RE: Green Pasture Short Plat, Project No. SP-08-00053

Thank you for the opportunity to comment on the Green Pasture Short Plat, SP-08-00053. Pursuant to the Memorandum of Agreement between Kittitas County and the Washington State Department of Ecology all the future residential well connections serving the proposed lots shall be required to have meters installed. Metering results shall be recorded in a manner consistent with Kittitas County and Washington State Department of Ecology requirements.

TO: Allison Kimball, Community Development Services
FROM: Christina Wollman, Planner II *CW*
DATE: January 26, 2009
SUBJECT: Green Pastures Short Plat SP-08-00053

GREEN PASTURE SHORT PLAT
 PART OF SECTION 36, T. 18 N., R. 17 E., W.M.
 KITTITAS COUNTY, WASHINGTON

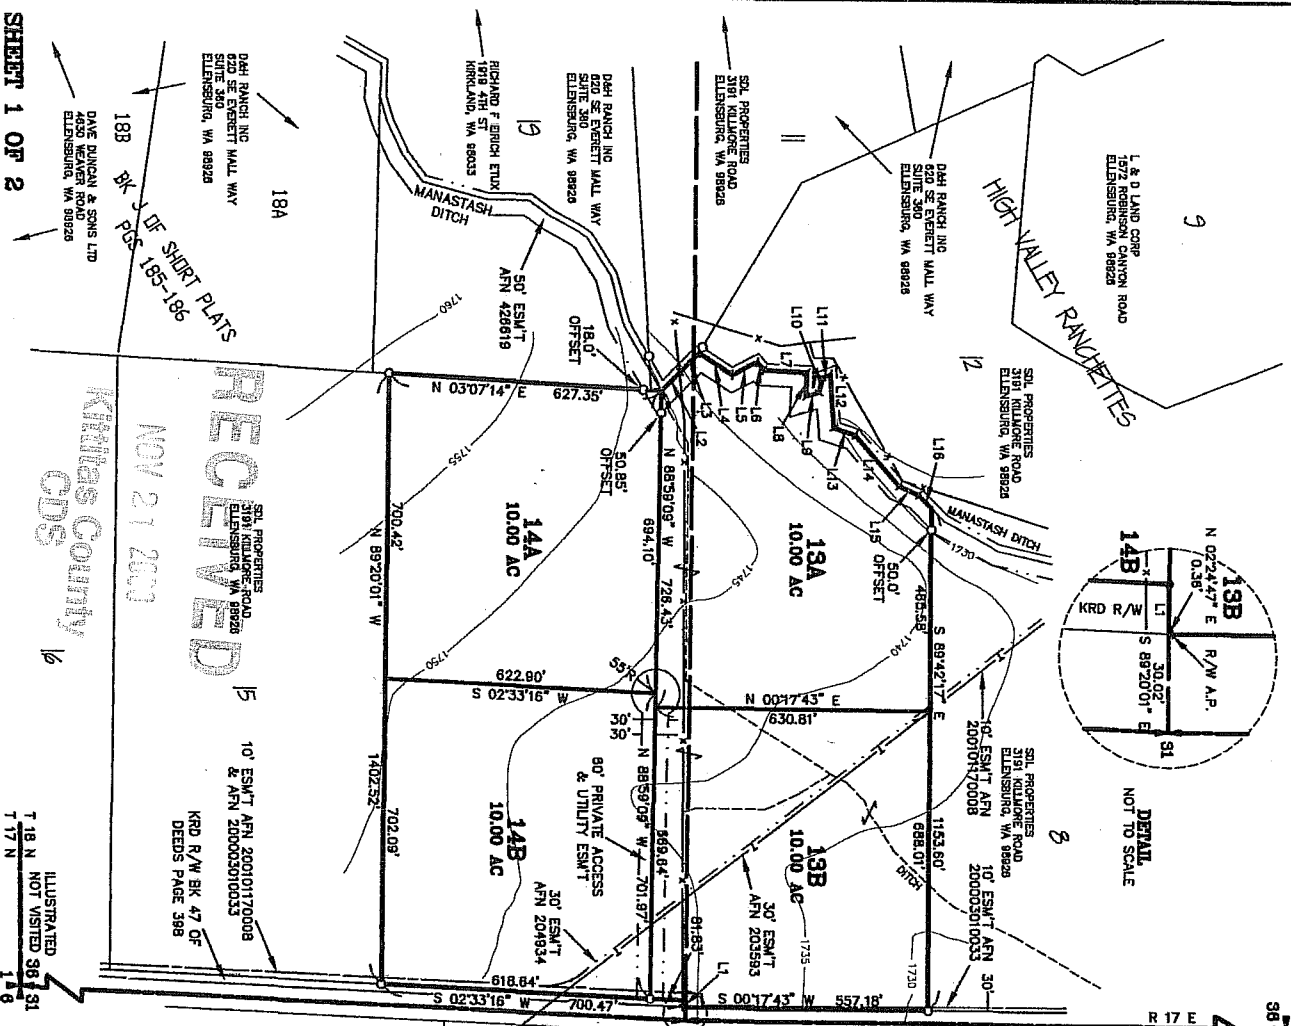
The potable water plat note is incorrect (plat note #8). Please replace the plat note with the following:

Please also include the following plat note:

3. Access: All access shall be from the private road. No direct access to Cove Road will be allowed.
4. Private Road Improvements: Access from Cove Road to the cul-de-sac shall be constructed as a Low-Density Private Road. See Kittitas County Road Standards, 9/6/05 edition.

- a. Access easements shall be a minimum of 60' wide. The roadway shall have a minimum width of 20', with 1' shoulders, for a total width of 22'.

- b. Minimum centerline radius will be 60'.
 - c. The surface requirement is for a minimum gravel surface depth of 6".
 - d. Maximum grade is 12%.
 - e. Stopping site distance, reference AASHTO.

5. Cul-de-Sac: A cul-de-sac turn-around having an outside right-of-way or easement diameter of at least 110 feet shall be constructed at the closed end of all dead-end roads serving 3 or more lots. The driving surface shall be at least 96 feet in diameter. Cul-de-sacs must also conform to the requirements specified by the 2006 International Fire Code. Contact the Fire Marshal regarding any additional cul-de-sac requirements.

"The approval of this division of land includes no guarantee that there is a legal right to withdraw groundwater within the land division. The approval of this division of land provides no guarantee that use of water under the ground water exemption (RCW 90.44.050) for this plat or any portion thereof will not be subject to curtailment by the Department of Ecology or a court of law."

"Metering will be required on all residential well connections and metering results shall be recorded in a manner consistent with Kittitas County and Washington State Department of Ecology requirements."
